CITY OF ALBUQUERQUE

February 22, 2023

RE: 3401 Calle Vigo NW
Grading and Drainage Plan
Engineer's Stamp Date: 12/21/21
Hydrology File: H12D003A1

DRAINAGE + GRADING PLAN

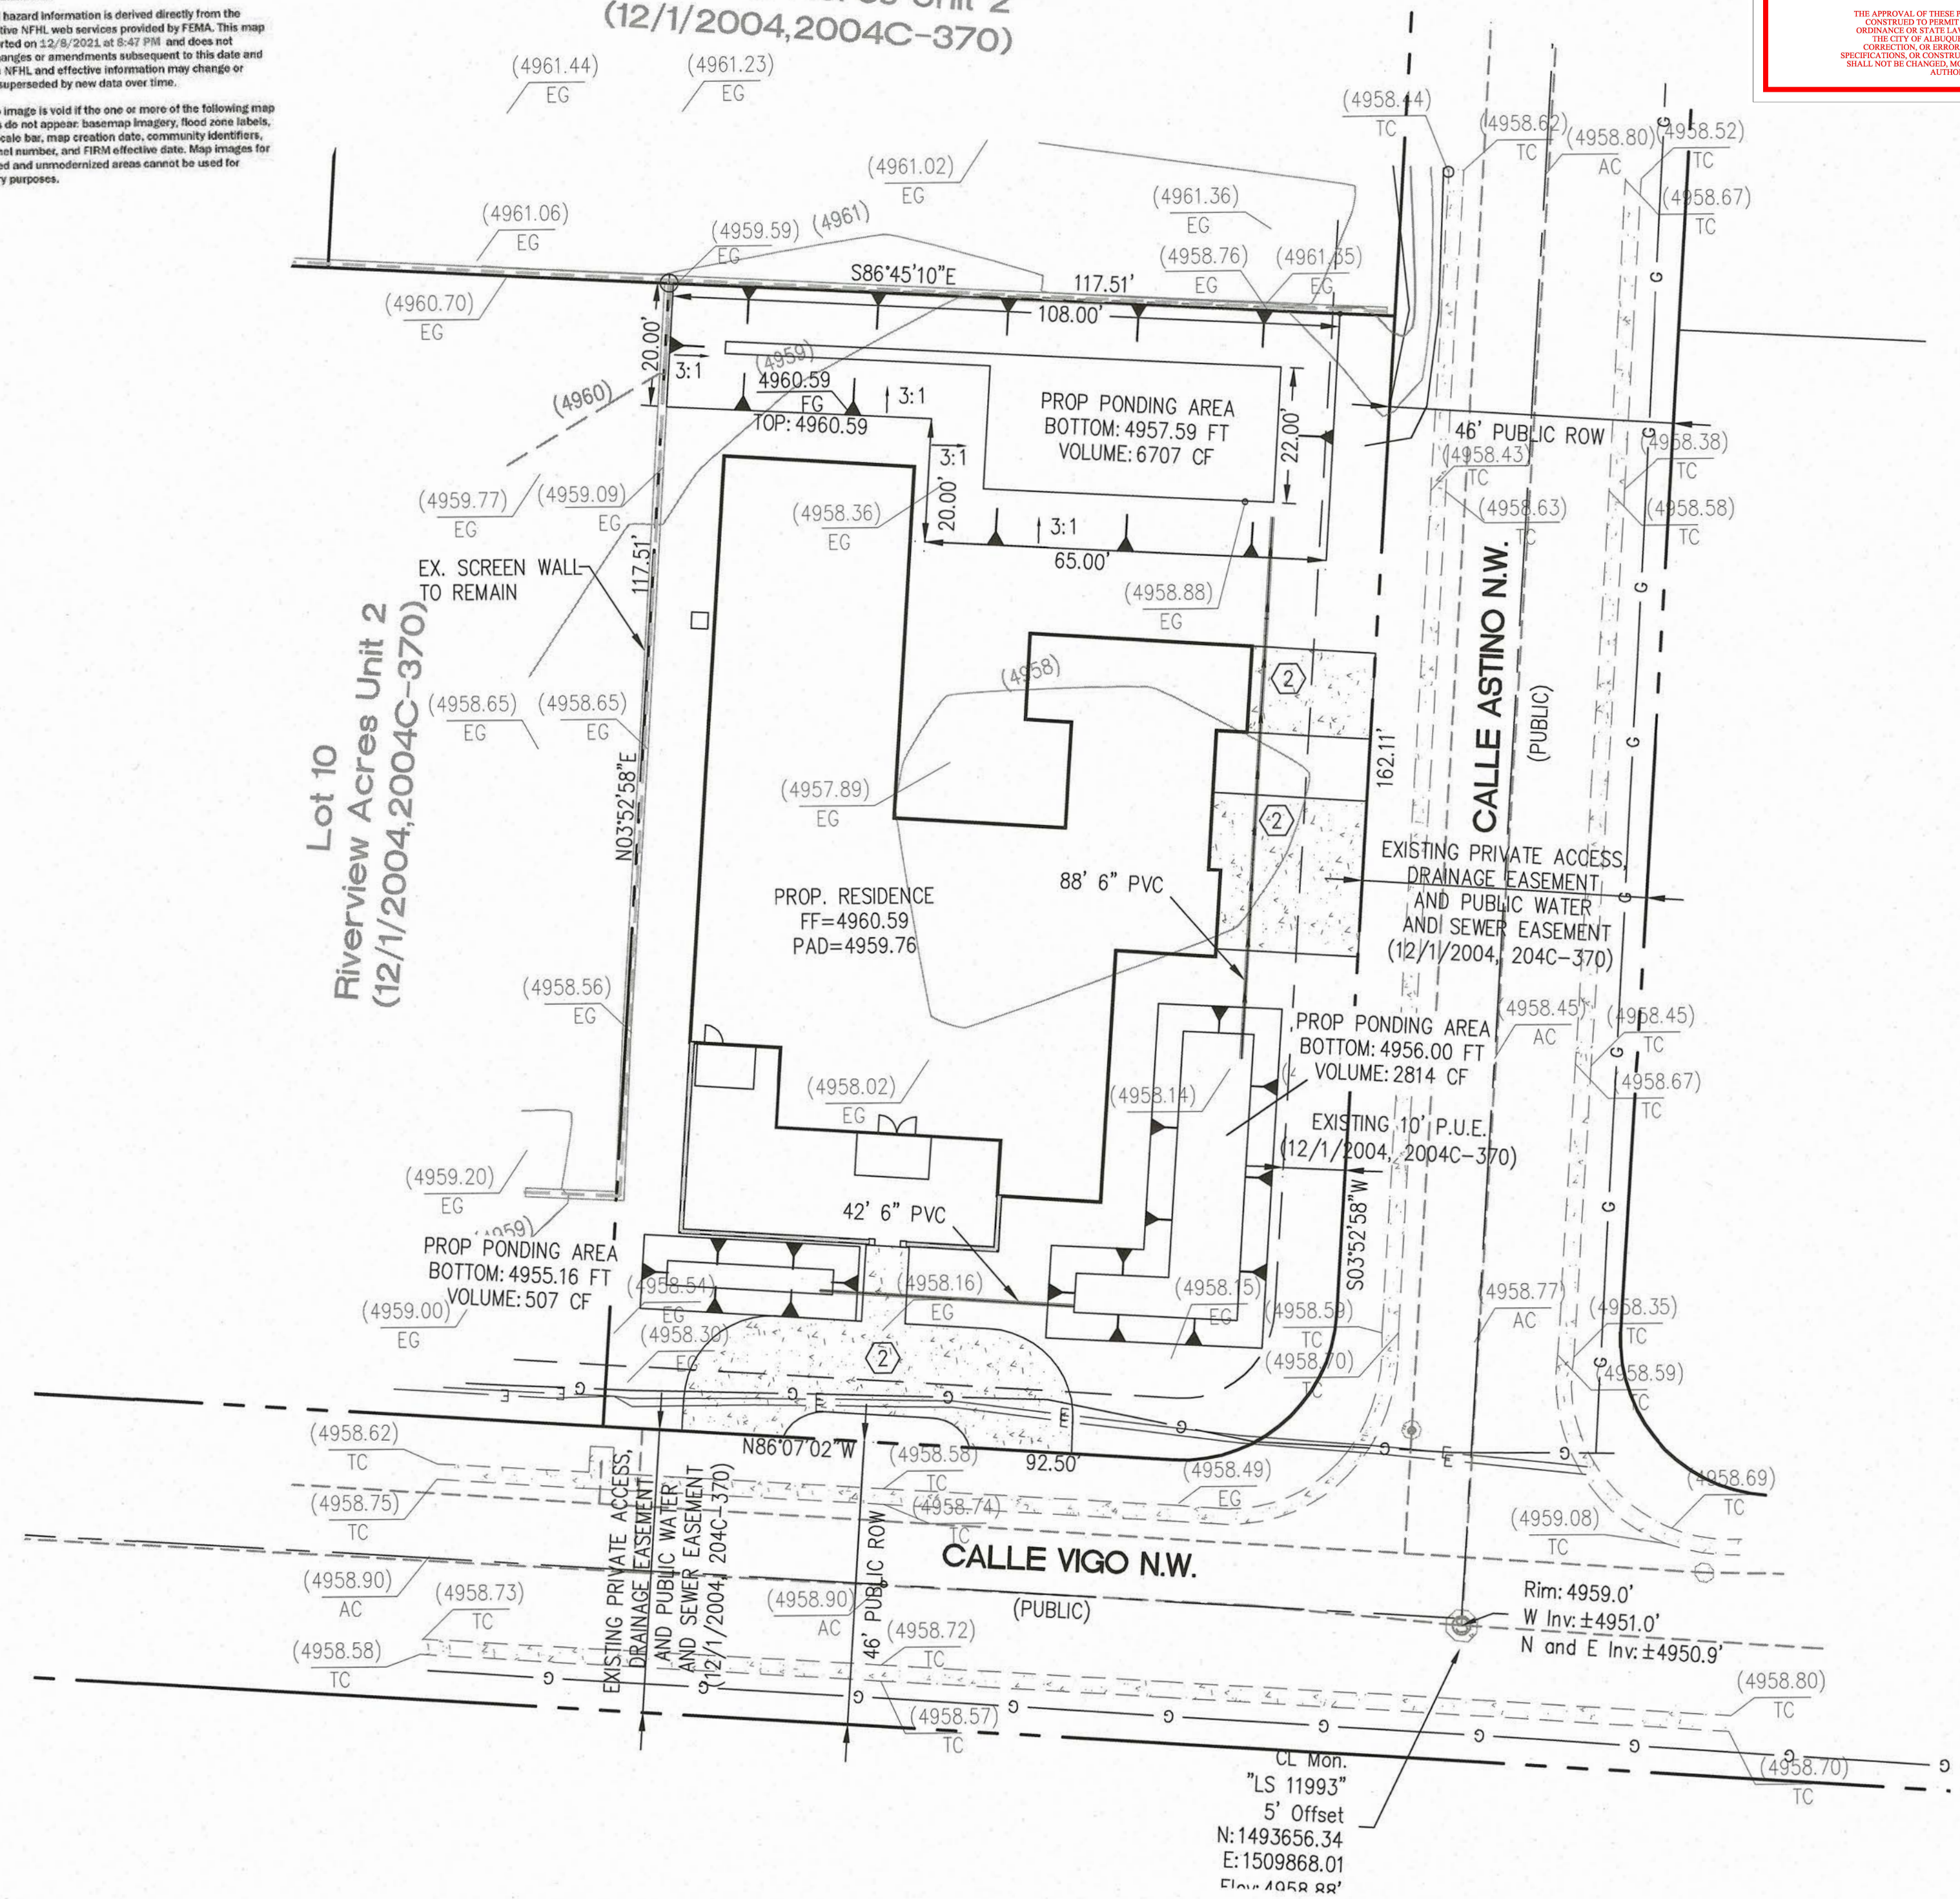
1. Since this site is in the Valley region, please follow Article 6-5 Valley Drainage Criteria of the DPM. The following conditions must be applied to the site:
 - a. The maximum percent impervious of the lot and the contributing area may not be greater than 45%.
 - b. Pad elevation shall be a minimum of one (1) foot above the 100 year 10-day stormwater surface elevation.
 - c. The flow between the front yard and back yard cannot be obstructed. The stormwater must be allowed to equalize to the same level between the front yard and back yard.
 - d. A permanent perimeter wall or barrier around the development is required to contain the 100-year 24-hour storm developed runoff.

2. According to the approved Master Grading Plan, this site has a maximum pad size of 5,596 SF and a required retention pond volume of 0.279 AC-FT or 12,153.22 CF. This design will have to be revised to accommodate this requirement. The site flows outside the Building Lines drains to the street(s) and the flows inside the Building Lines drains to the rear retention pond.
